## Application by Morgan Offshore Wind Limited and Morecambe Offshore Windfarm Limited for the Morgan and Morecambe Offshore Wind Farms Transmission Assets

The Examining Authority's written questions and requests for information (ExQ2) issued on 8 September 2025

Figure 1.6: Biodiversity benefit area at Lea Marsh Fields

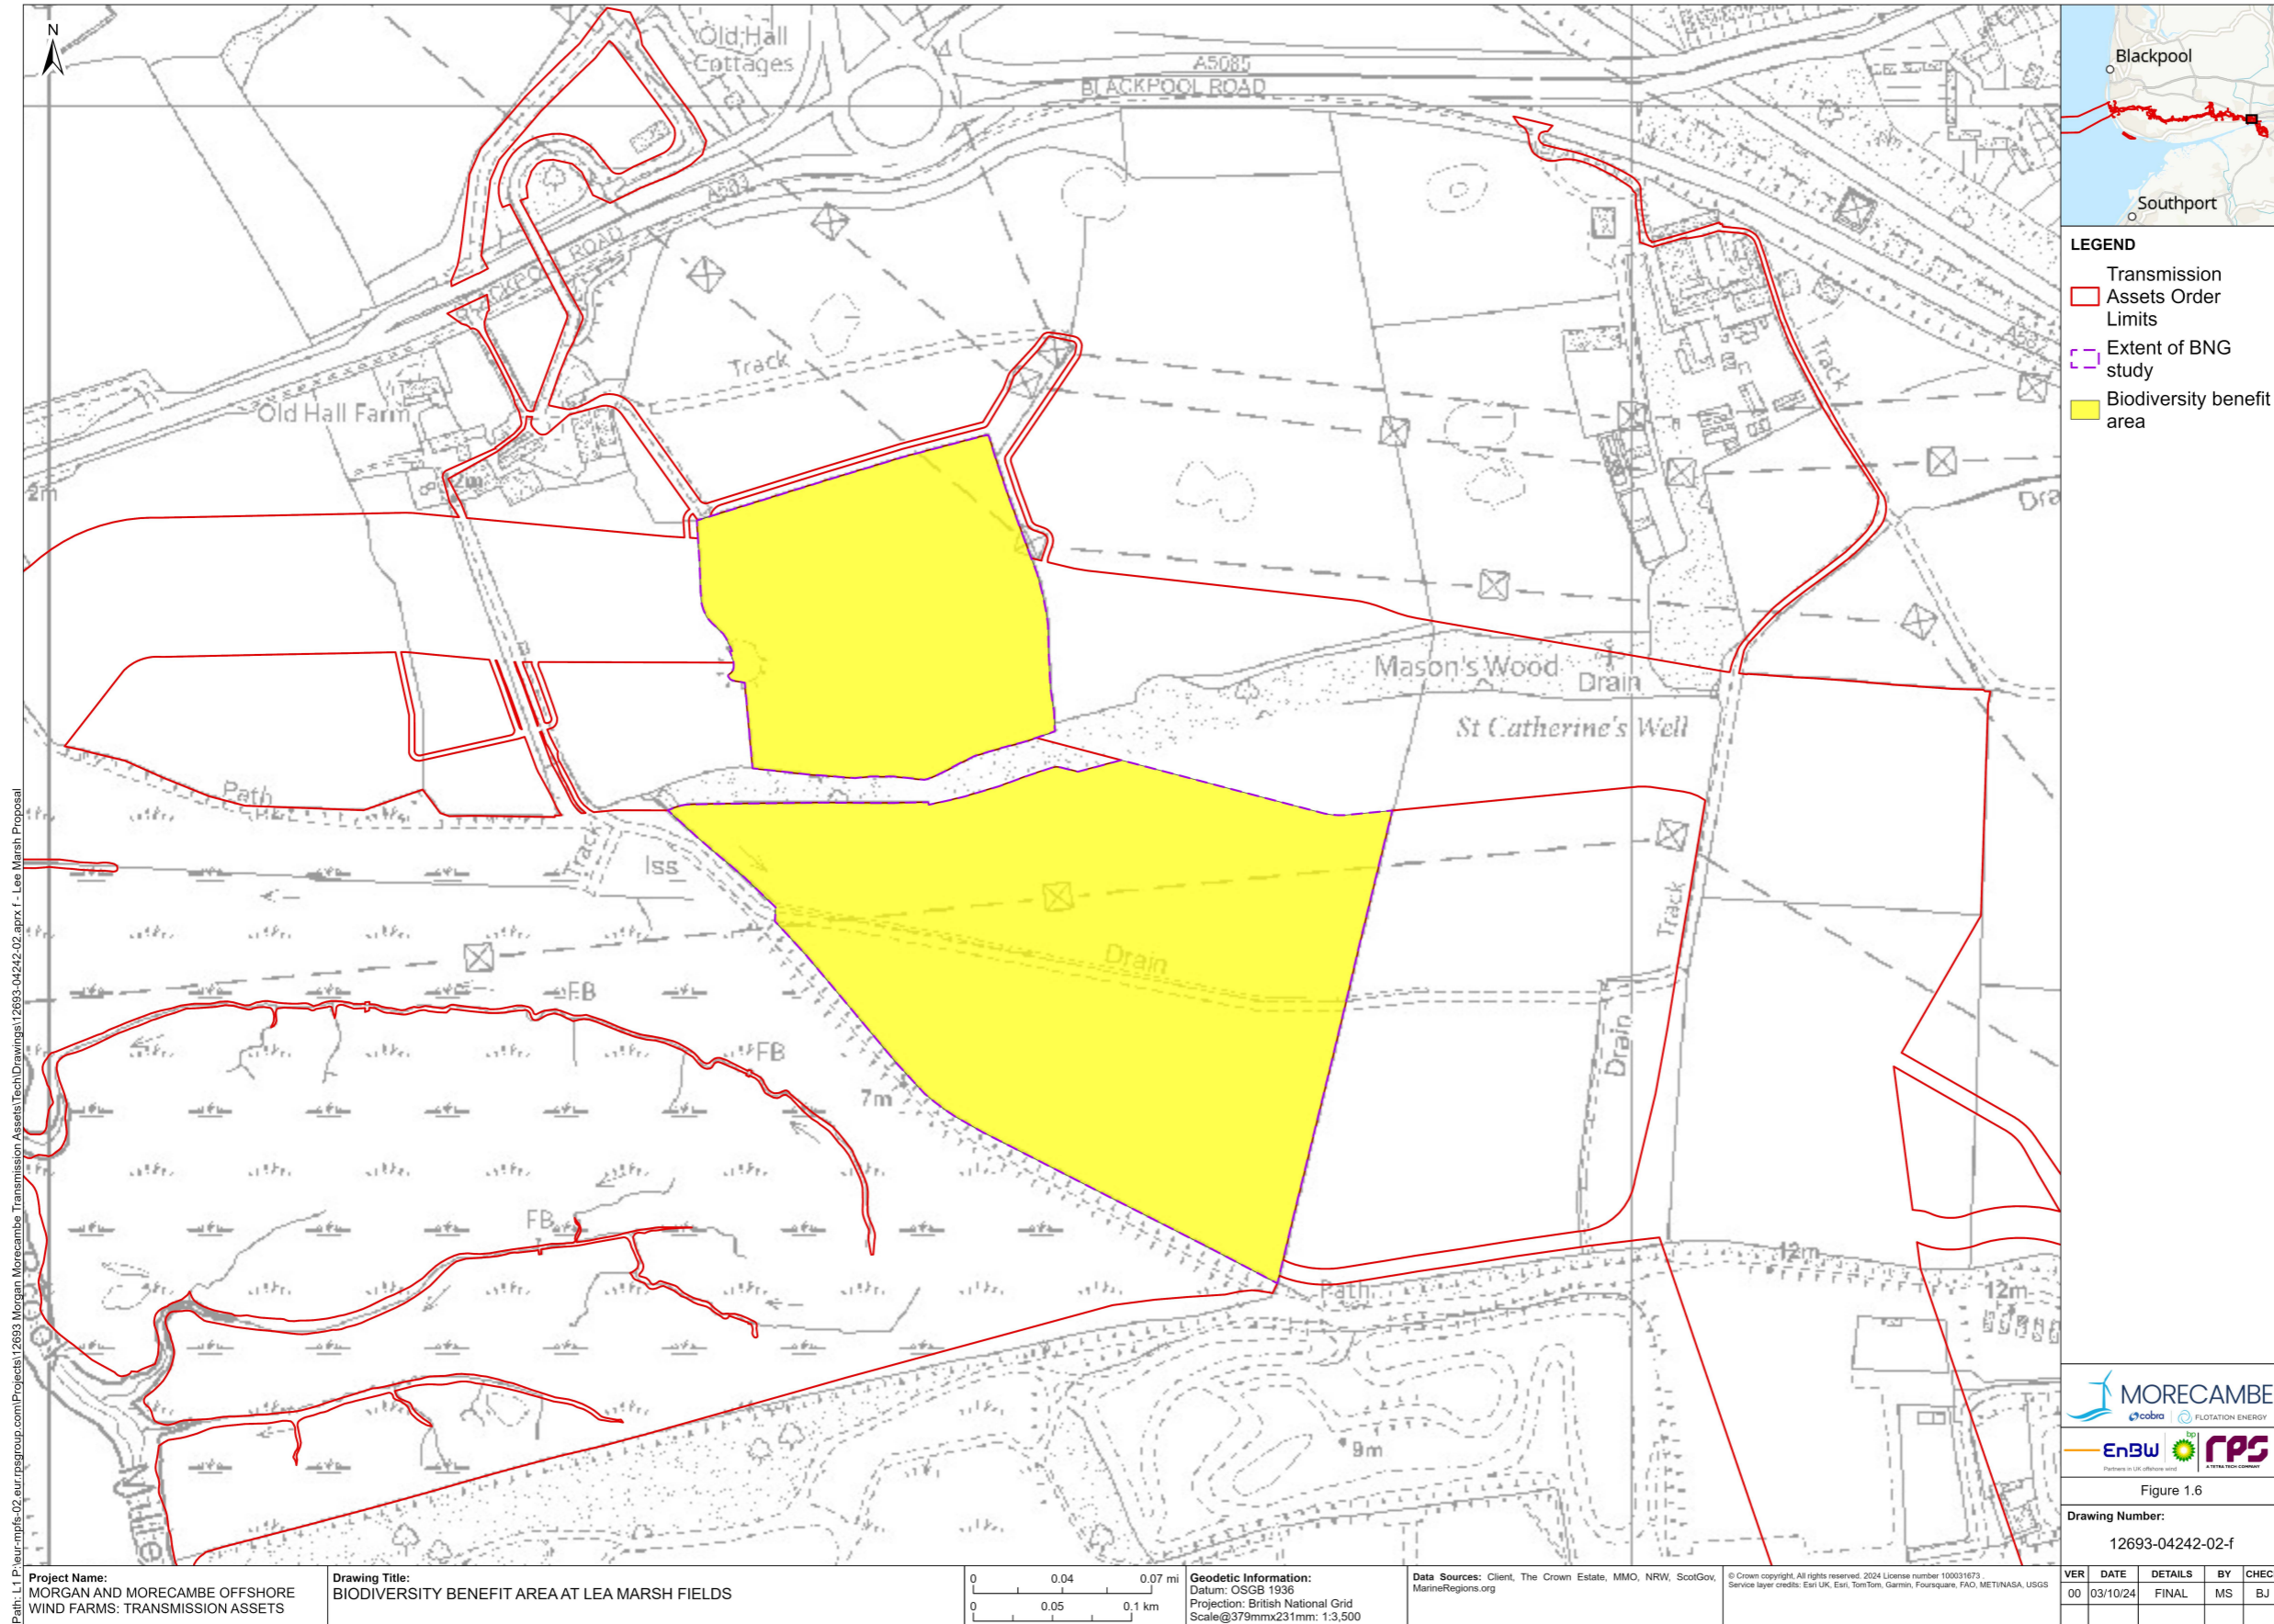
Q2:5.1.12	The applicants	<p><b>Lea Marsh</b></p> <p>BAE take a similar approach <a href="#">[REP4-127]</a> and emphasise that “the Biodiversity Benefit Site at Lea Marsh is not mitigating any impact and therefore there should not be any locational requirements from an ecological perspective.” They continue in their submission “Given that there is no requirement for BNG, or indeed any need for the biodiversity benefit sites to be provided at all, there is no reason why the biodiversity benefit site could not be located outside of Warton Aerodrome’s 13 km wildlife hazard safeguarding zone, where potential harm to aviation operations from an increased bird strike risk is likely to be lower”. Why have the applicants not looked for a site outside the 13km safeguarding zone?</p>
Q2:5.1.13	The applicants	<p><b>Local benefits</b></p> <p>The local benefits of the project appear to be very limited although the ExA notes the overall advantages arising from the urgency of energy infrastructure and the single application for two projects as summarised in action point 26 from issue specific hearing 1 (ISH1) <a href="#">[REP3-041]</a>. However, the SoR <a href="#">[REP4-016]</a> still refers (at paragraph 1.5.1.7) to the local benefits not being a material planning consideration. This would not seem to be relevant when addressing compulsory acquisition and should be removed although the overriding argument is acknowledged.</p>
